From:
Sent: 11 January 2026 12:05
To: DC Admin
Subject: Formal Objection to Planning Application 2025/93355 - Highway Safety and Access Concerns

I am writing to formally object to planning application 2025/93355, relating to the proposed residential development on land off Woodward Court / Hepworth Lane.

TITLE	HEPWORTH LANE / FLASH LANE / SHILLBANK LANE EXISTING HIGHWAY LAYOUT
REF	FIGURE 11
SCALE	1:200 @ A3

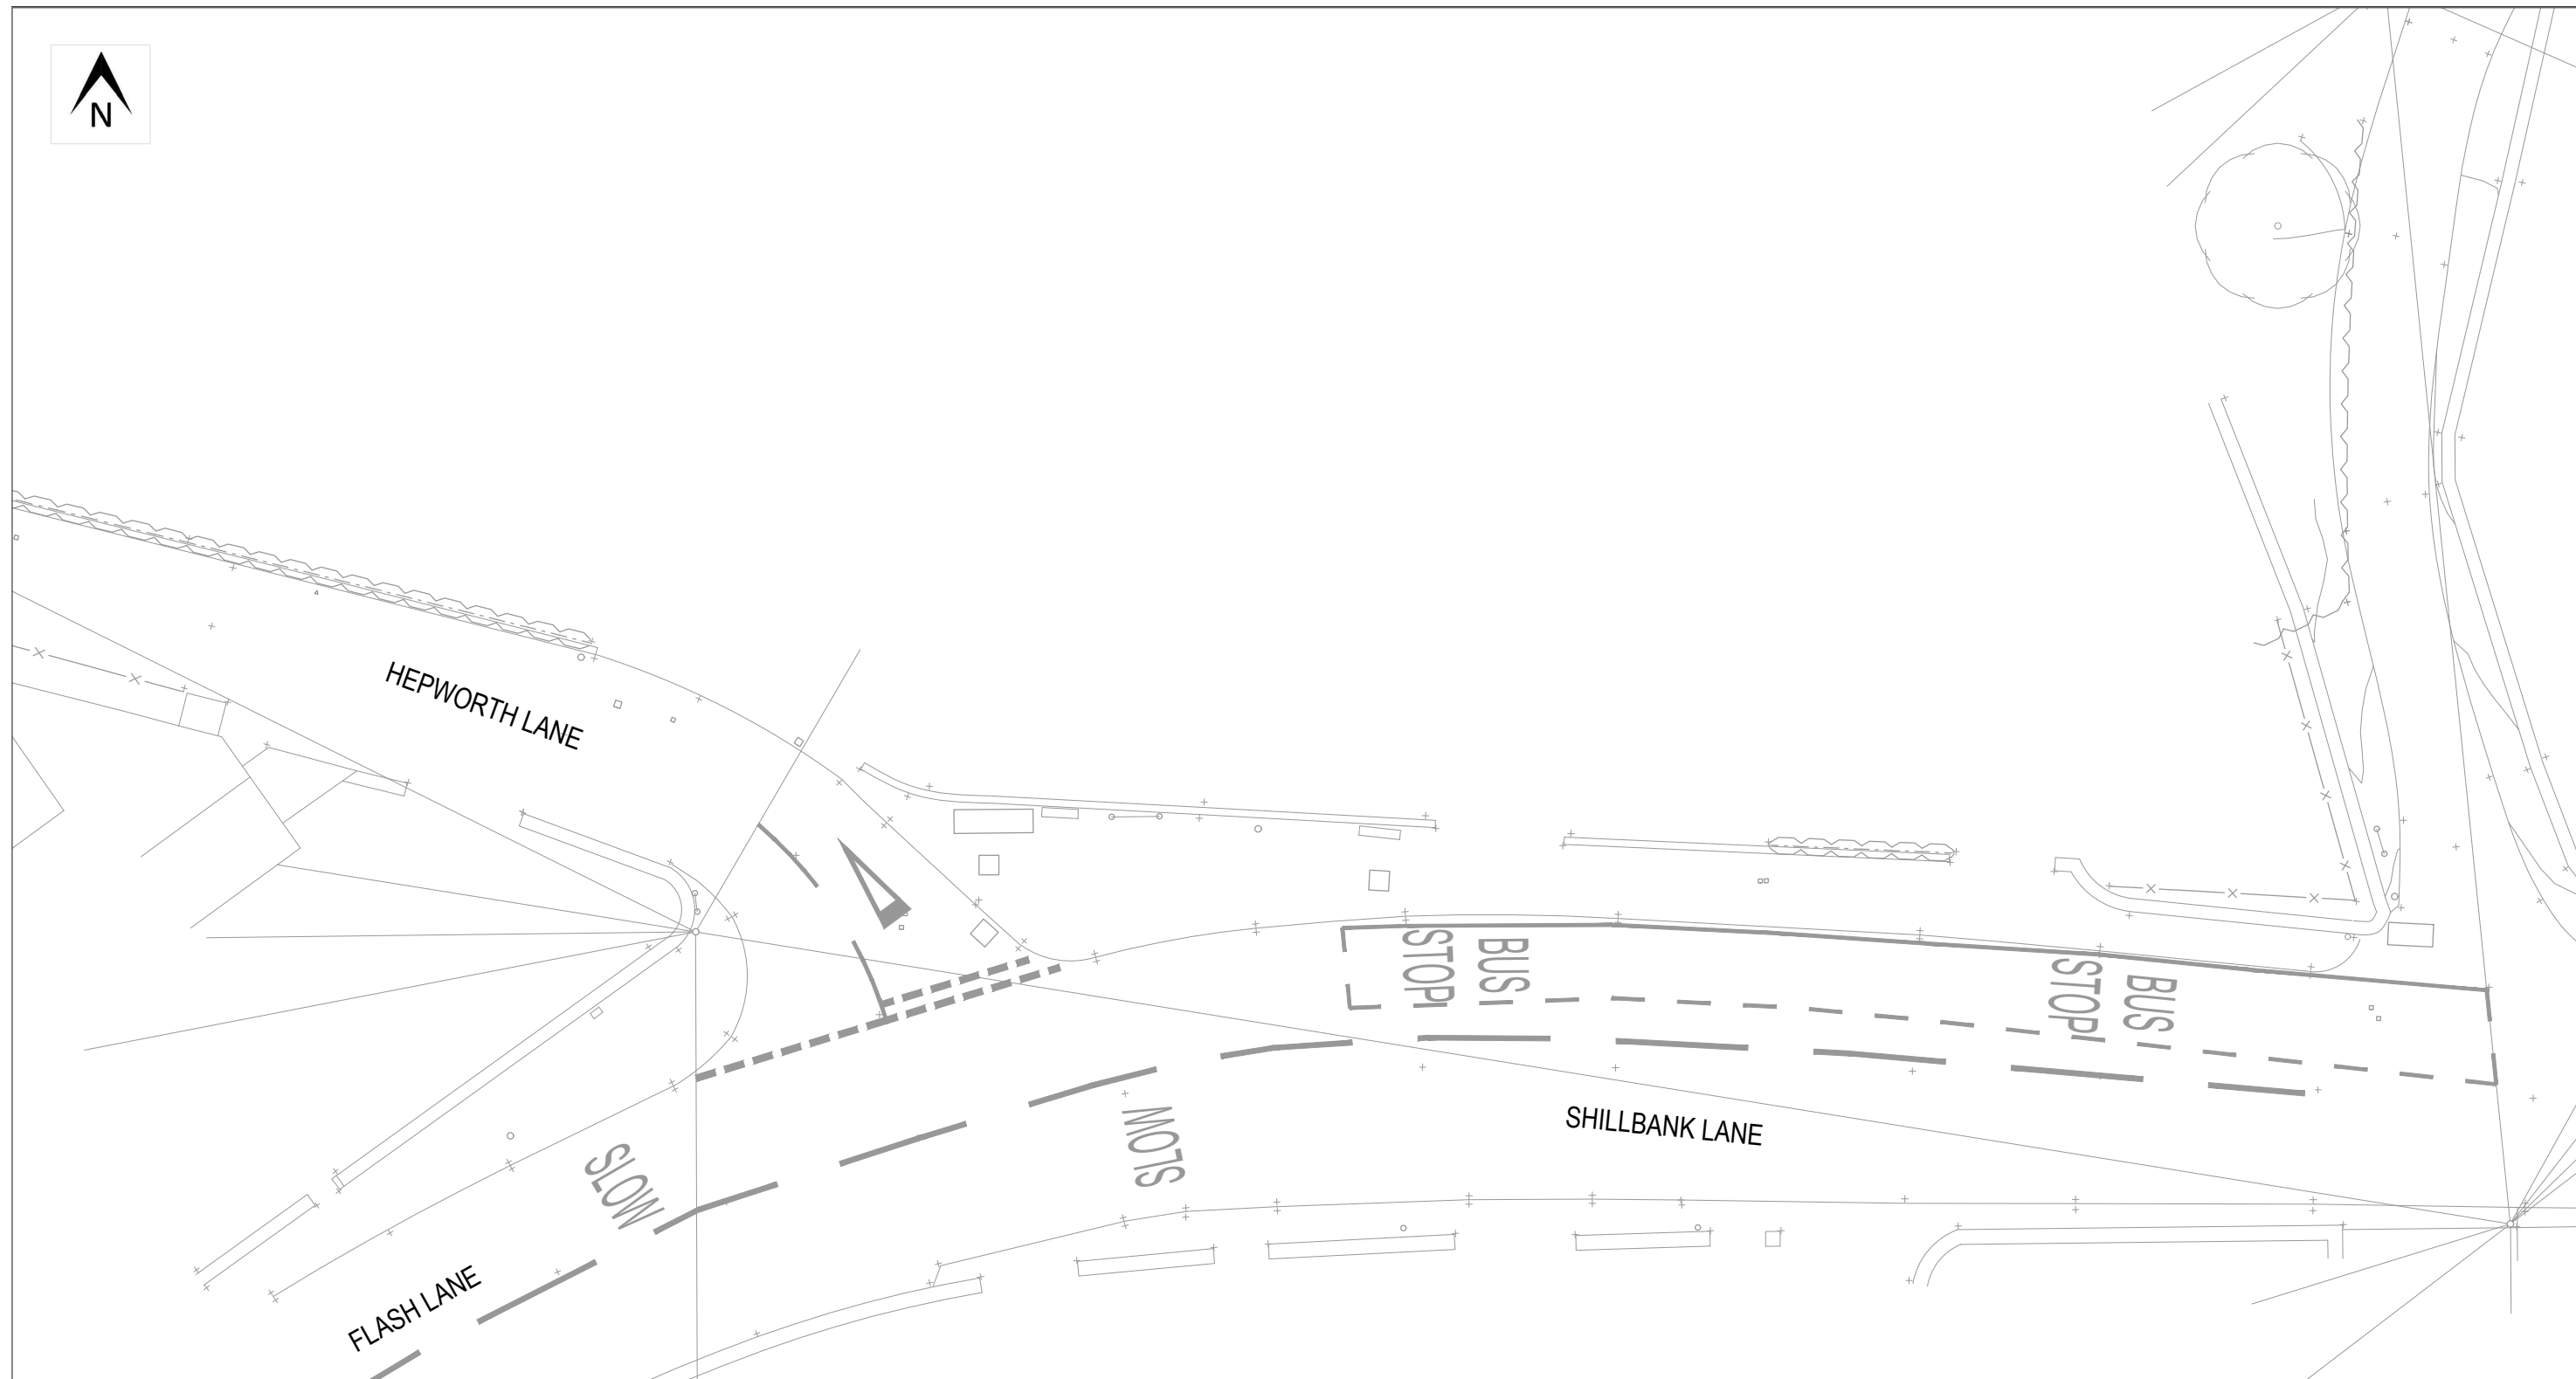
Hepworth Lane is a narrow, rural lane that is wholly inappropriate to function as a traffic route for a development of this scale. It has no pavements on either side for pedestrians, meaning that residents, including children and vulnerable road users, are forced to share the carriageway with vehicles. In several sections of the lane, it is physically impossible for two cars to pass at the same time, requiring one vehicle to stop and wait or reverse, often over a considerable distance. This is already problematic under existing traffic conditions and would be significantly exacerbated by additional development traffic.

The junction at the end of Hepworth Lane, where it meets the B road, presents further serious safety concerns. There is insufficient space at this junction for a vehicle turning into Hepworth Lane and a vehicle attempting to exit it at the same time. In practice, one driver must wait on the B road or reverse back into the lane, creating congestion and a clear risk of collisions. Any increase in traffic volume would intensify these risks and is, in my view, unacceptable.

The proposal appears to assume that Hepworth Lane can safely absorb additional vehicular movements without substantive alteration to its layout or capacity. This assumption is not credible. The physical constraints of the lane are fixed and cannot be resolved without extensive and intrusive highway works, which are neither proposed nor, realistically, achievable.

Taken together, the lack of pavements, insufficient road width, and unsafe junction geometry demonstrate that Hepworth Lane is fundamentally unsuitable as an access route for traffic associated with a development of this size. The proposal therefore fails to ensure safe and suitable access, contrary to core highway safety principles.
